PRE-REGISTRATION CHECK SHEET – TO BE COMPLETED BY DUTY OFFICER AS APPROPRIATE

Application Ref: 24/00164/DPP Pre-application Ref: _____ Online App

<p>UPRN: 000120031919 (If NO UPRN – Admin to contact Technician)</p> <p>Site Address: <i>(Leave blank if no UPRN)</i> UNIT 38 DRYDEN ROAD LOANHEAD EH20 9LZ</p>	<p>Description of Proposal: Extension at first floor level to provide office facility and erection of associated two storey extension to provide access</p>
---	--

CLIENT: ZENITH STRUCTURAL ACCESS		
PROJECT: PROPOSED ALTERATIONS AND EXTENSION TO UNIT		
ADDRESS: BILSTON GLEN INDUSTRIAL ESTATE, 38 DRYDEN ROAD, LOANHEAD, MIDLOTHIAN, EH20 9LZ		
DRAWN BY: CSD	CHECKED BY: CM	DATE: JANUARY 2024
DRAWING SCALE (A1): 1:200 & 1:500		DRAWING NUMBER: UD23/041/PLAN/007A

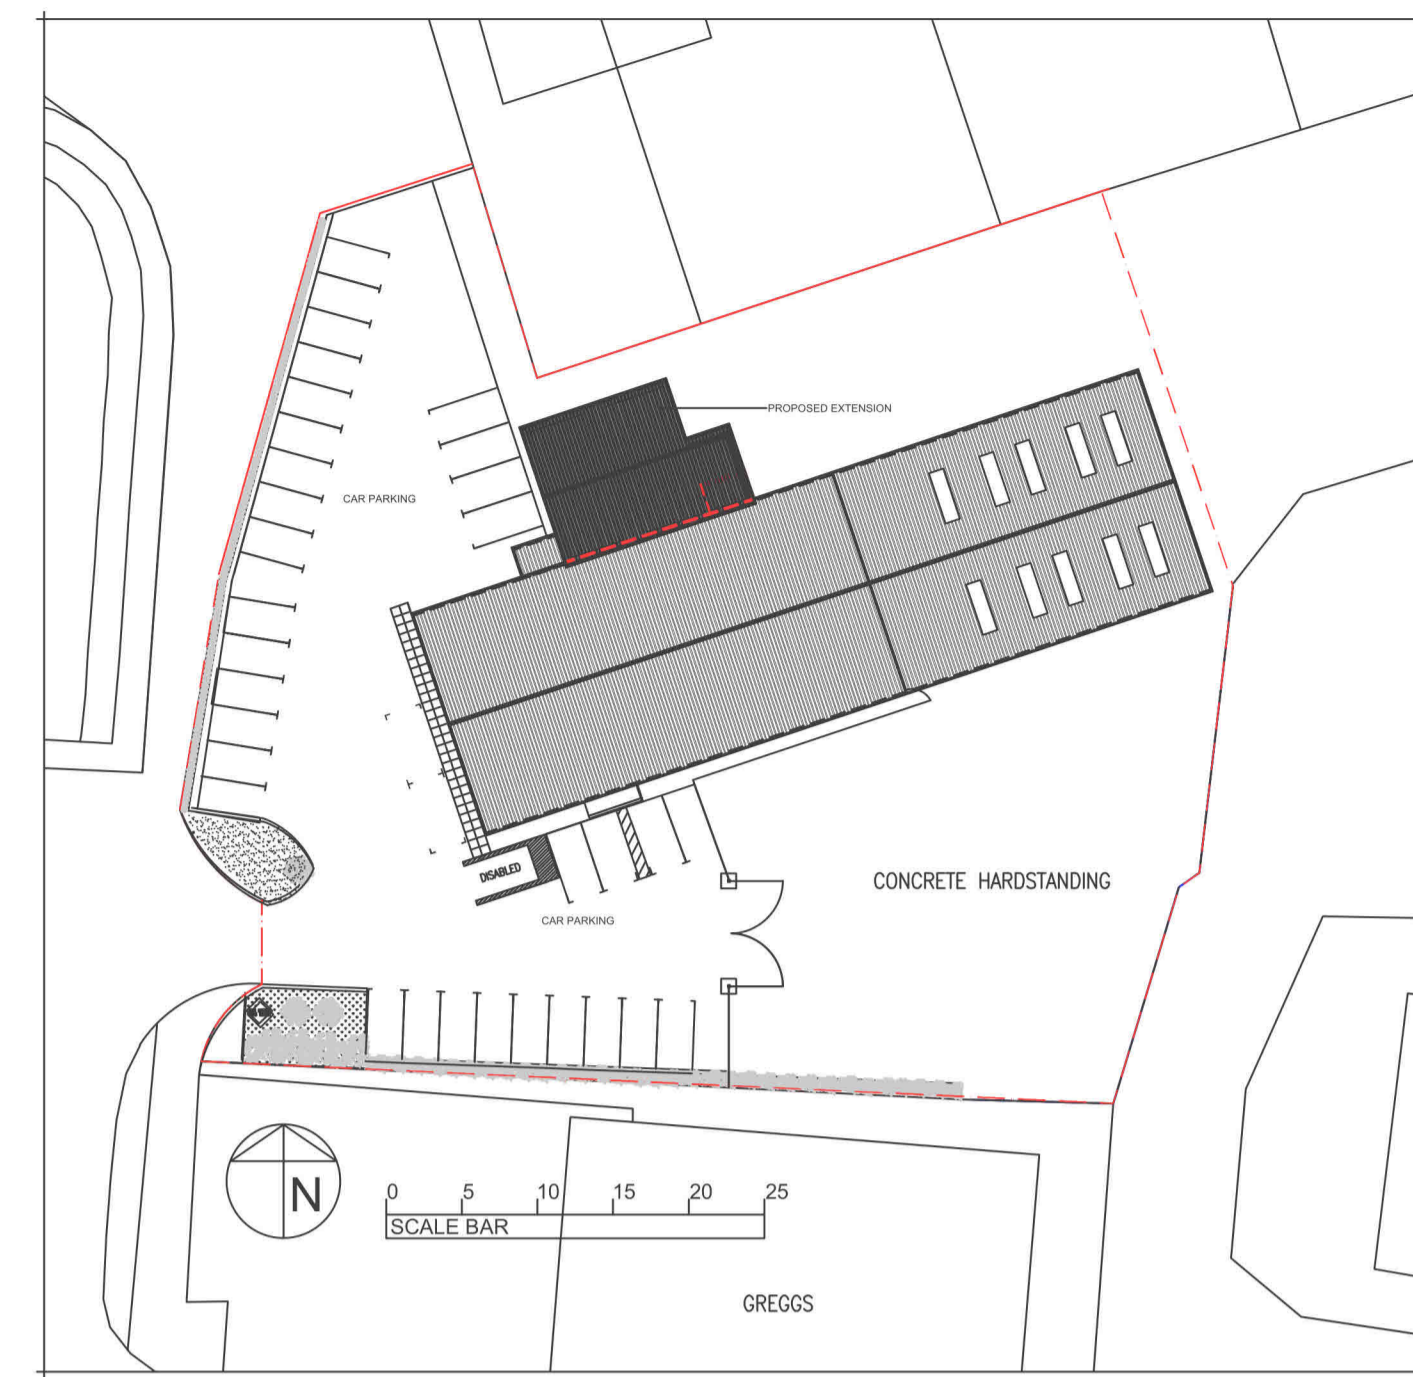
| <input checked="" type="checkbox"/> | Inadequate Plans | The following additional plans are required: <ul style="list-style-type: none">- The scale bars on drawing no. UD23/041/PLAN/007 are not scaling, can this please be checked. |
